Project Name:	Liberty Bay Recovery Center	Project ID:	2017-086
Address:	343 Forest Avenue	CBL:	112-D004
Applicant:	Nathan Cermelj		
Planner:	Matthew Grooms

On September 25, 2017, the Planning Authority approved a Level II Site Plan application for site work to include reconfiguration and improvement of leased parking spaces on City property and the development of a patio area to the rear of the existing building at 343 Forest Avenue in the B-2b zone. The decision is based upon the application, documents and plans as submitted. The proposal was reviewed for conformance with the standards of Portland's Site Plan Ordinance.

SITE PLAN REVIEW

C2.1

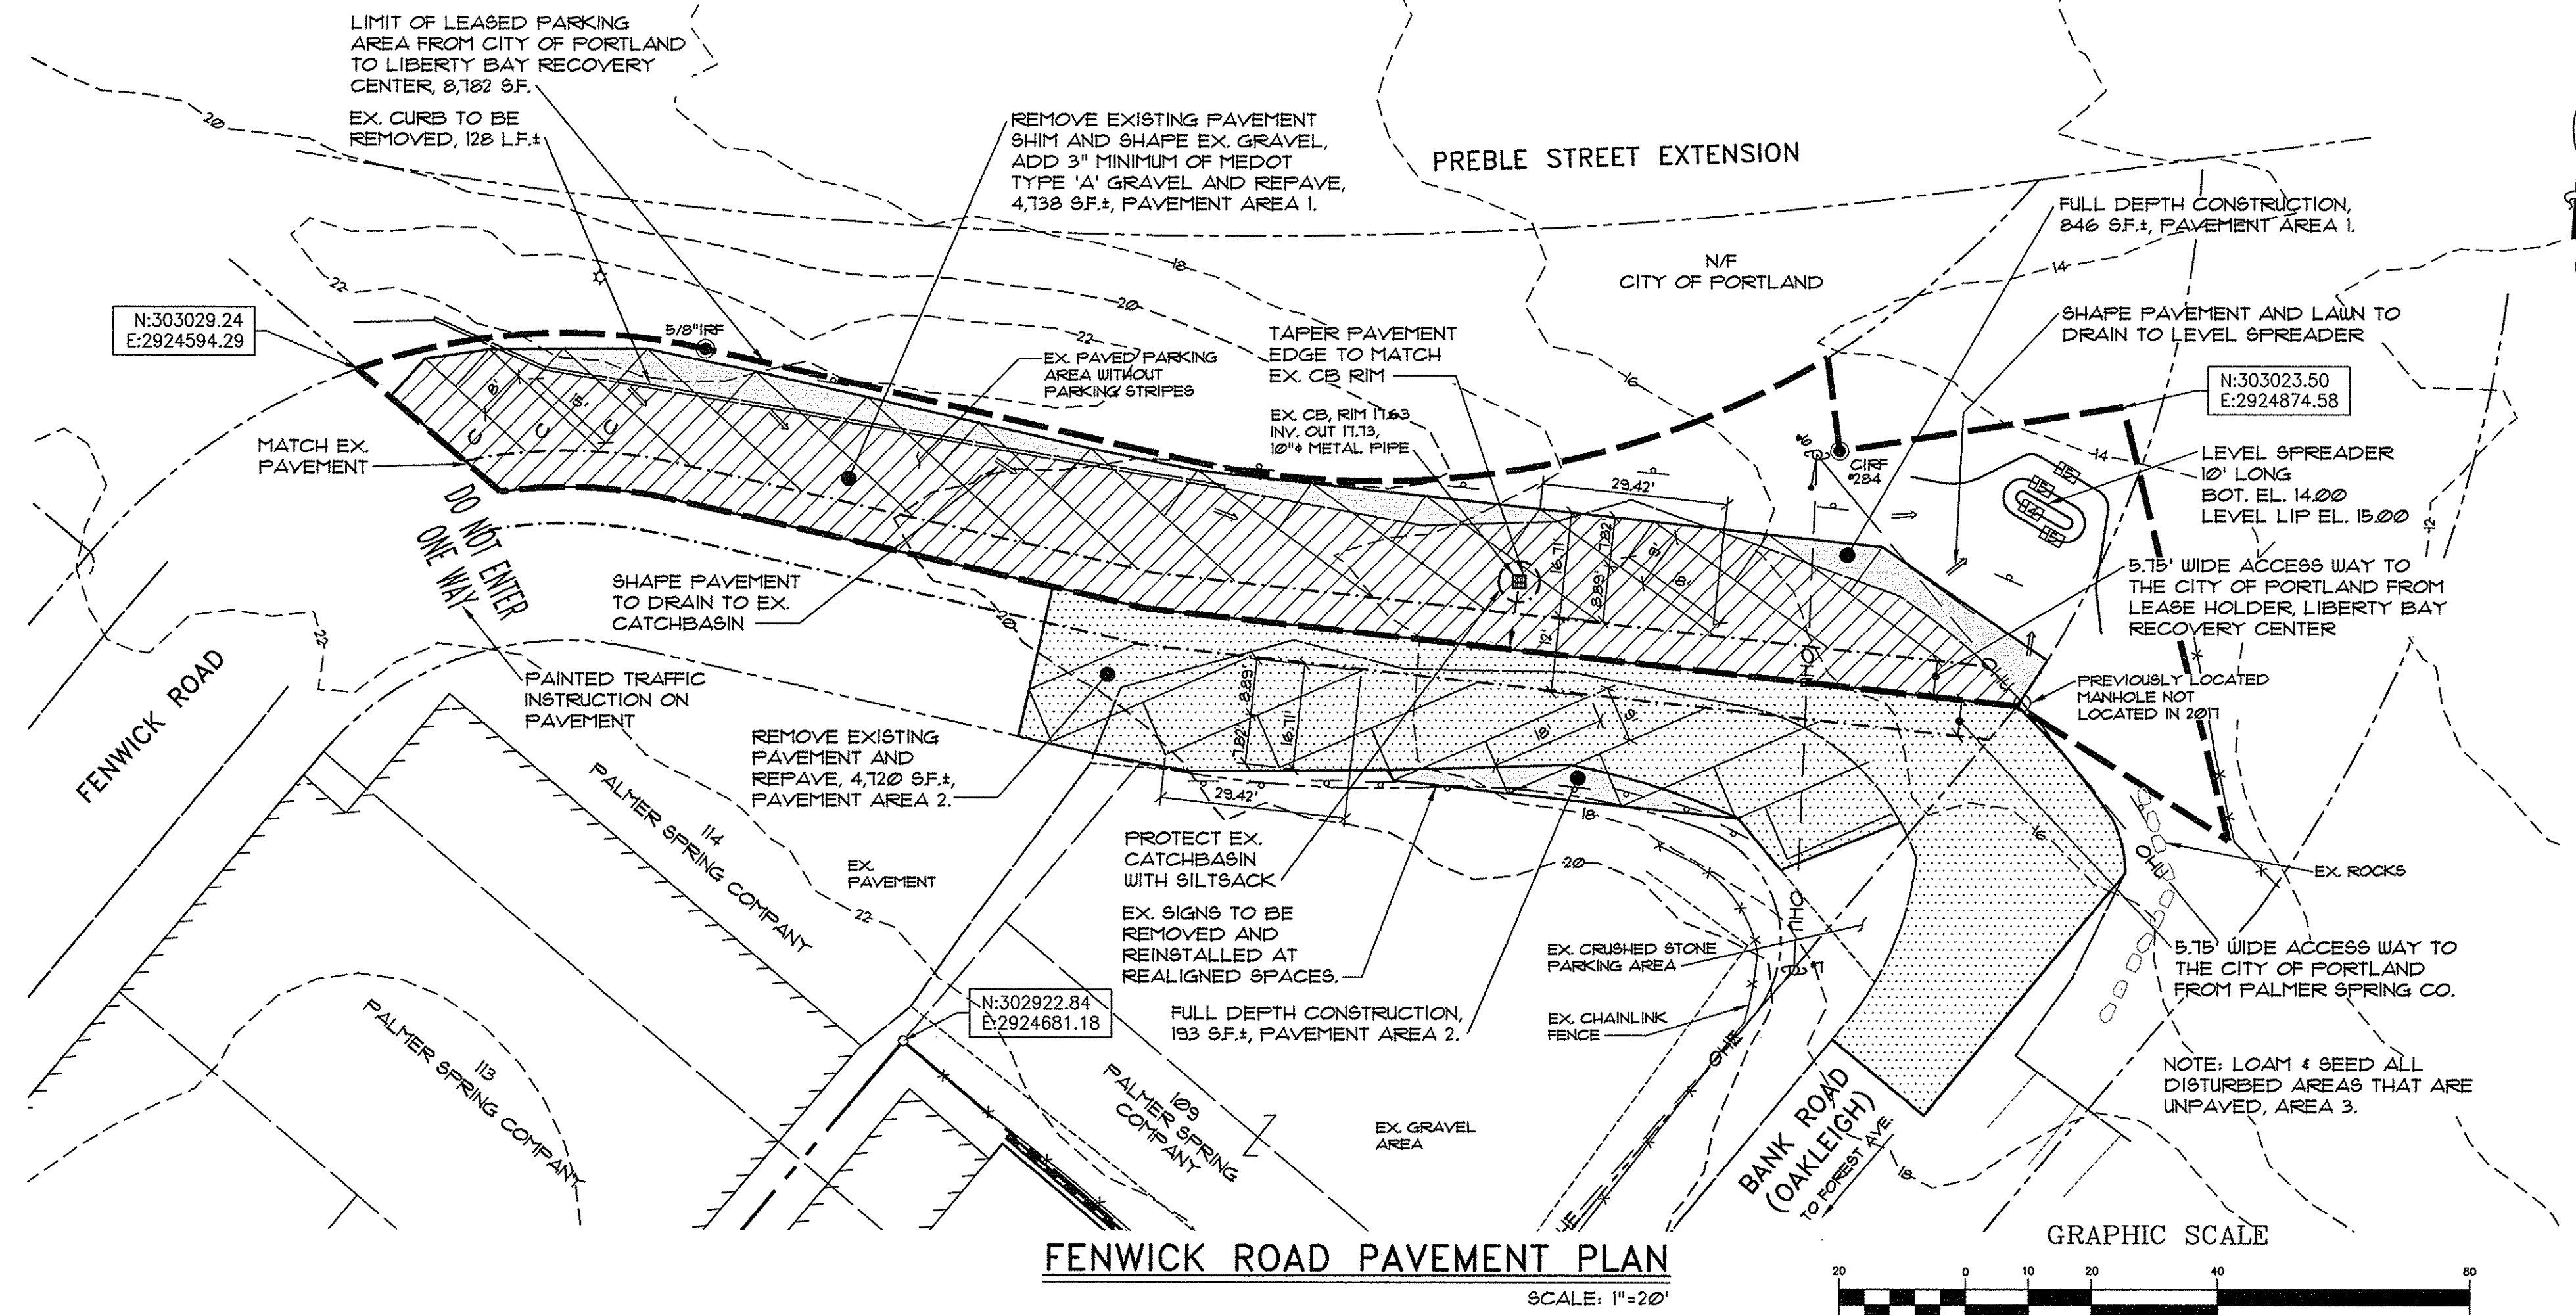
3. The two access way notes found on Sheet C2.1 reading "6' wide access way to the City of Portland from..." shall be consolidated into one note reading "Maintain a 12-foot wide vehicles and pedestrian public access centered on the lease limit line"; and

CONSTRUCTION MANAGEMENT PLAN
 11/8/17

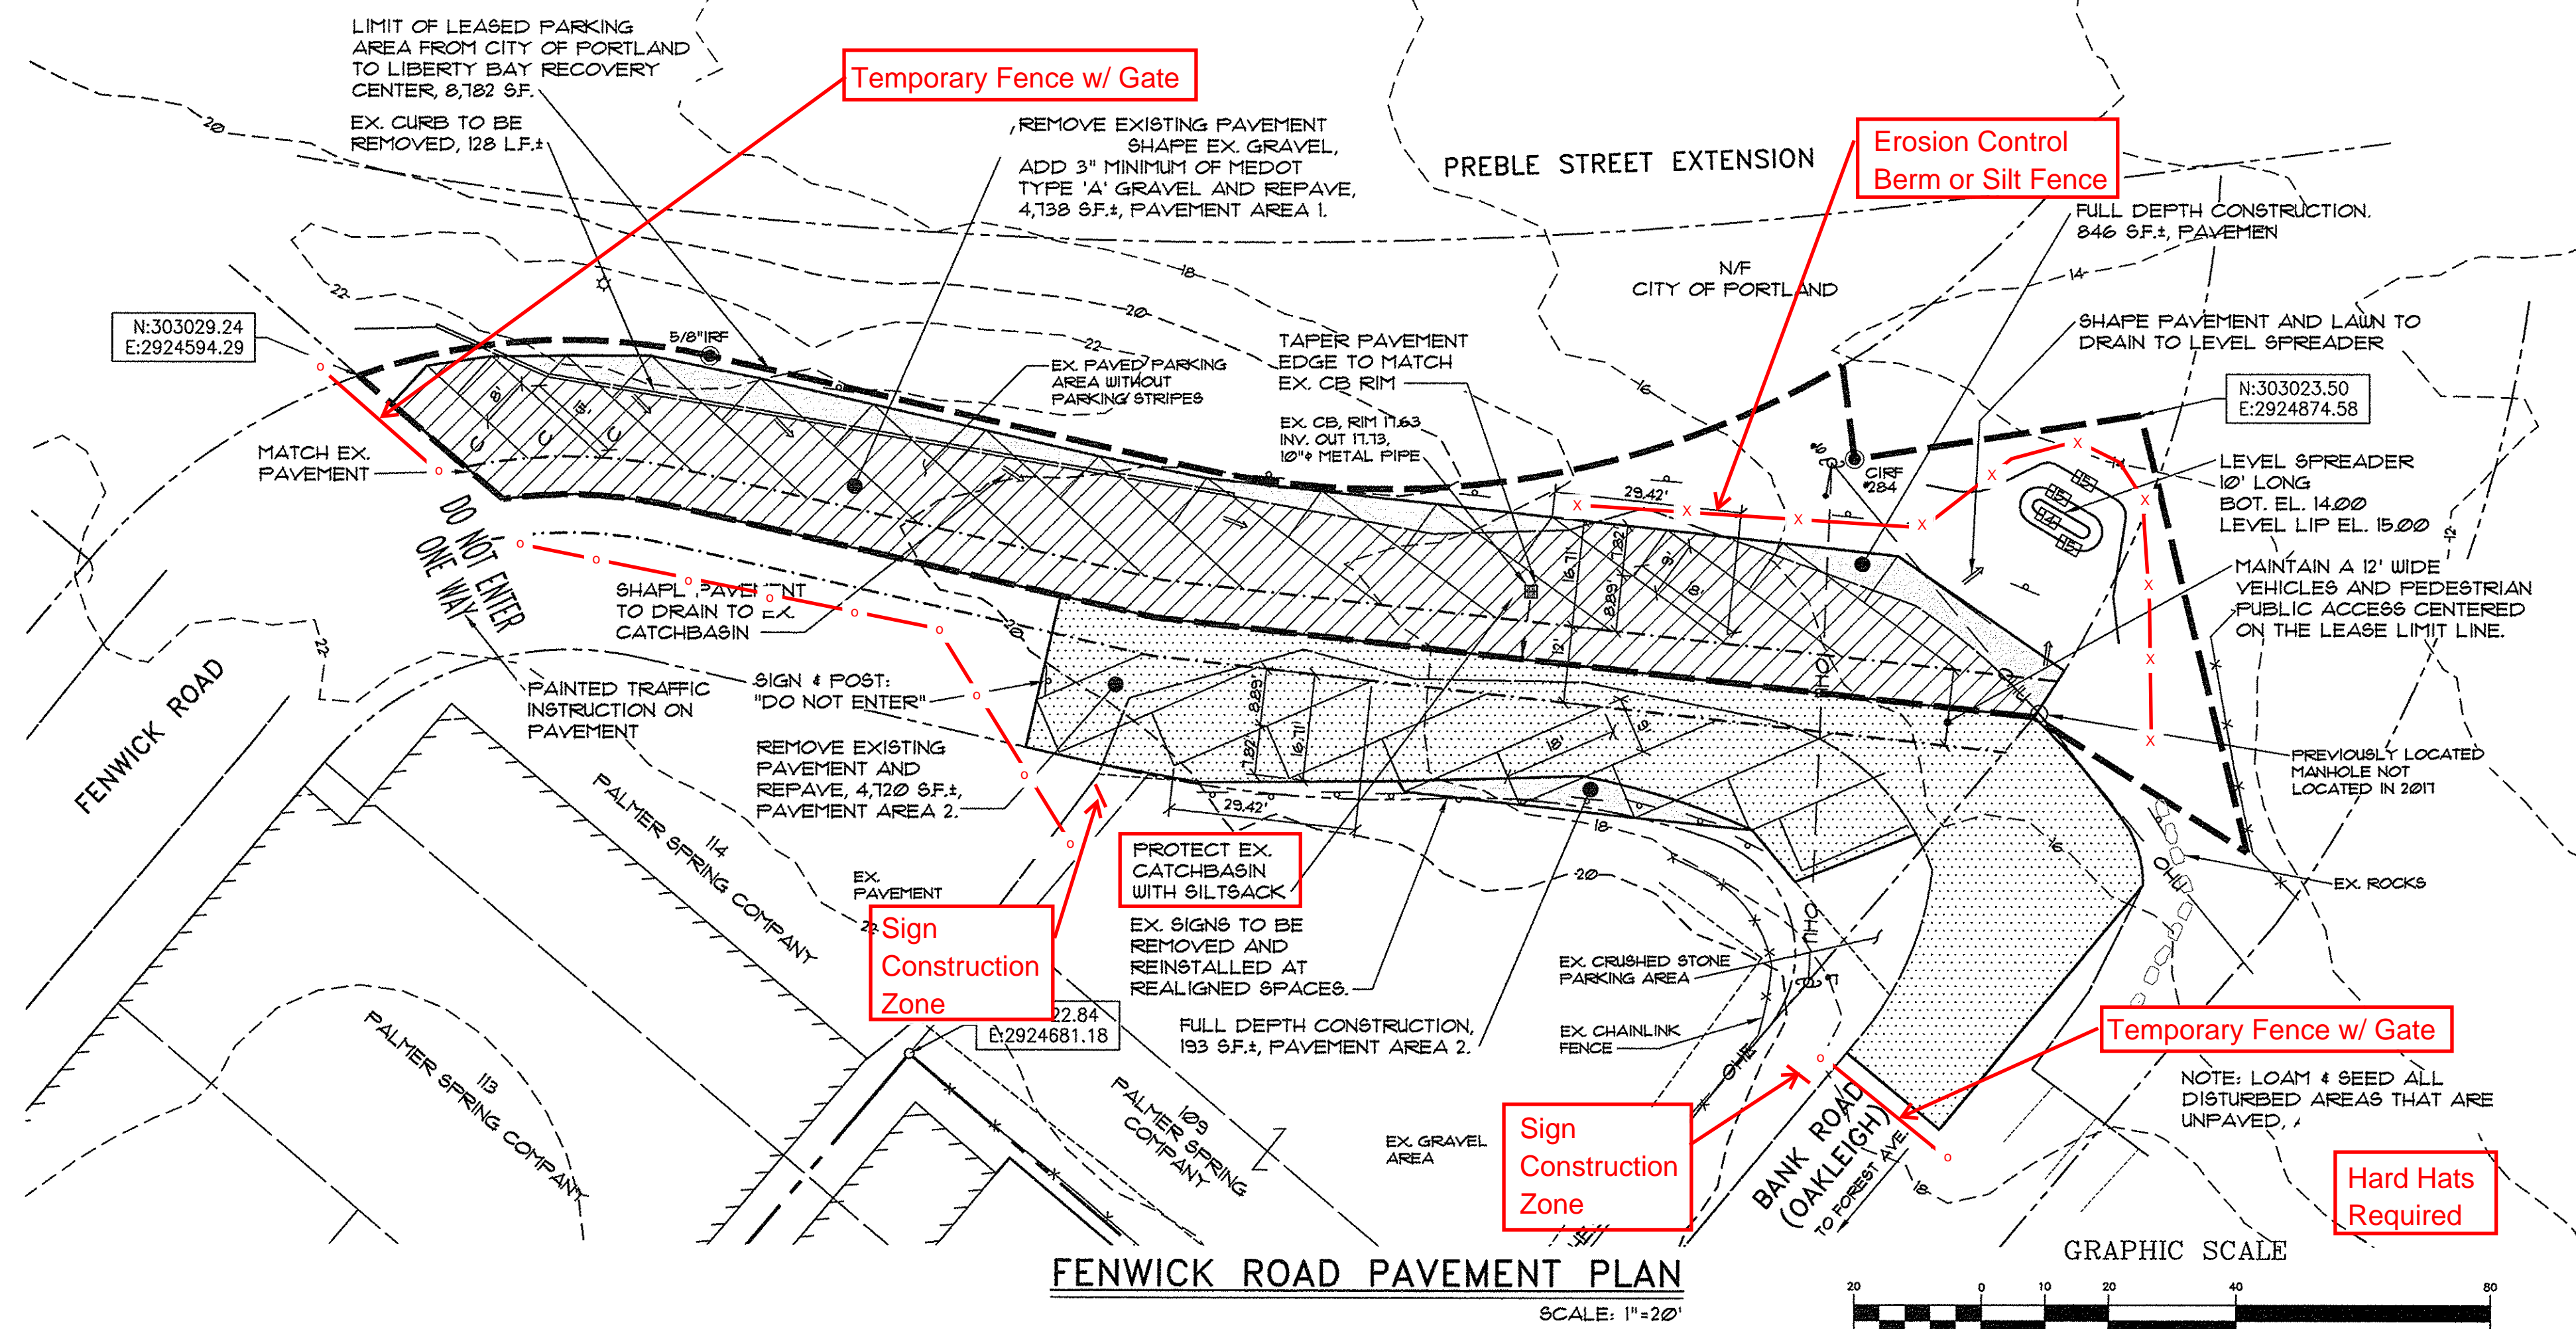
5. A revised construction management plan that conforms to the city's CMP template shall be submitted for review and approval by the Planning Authority and Department of Public Works.
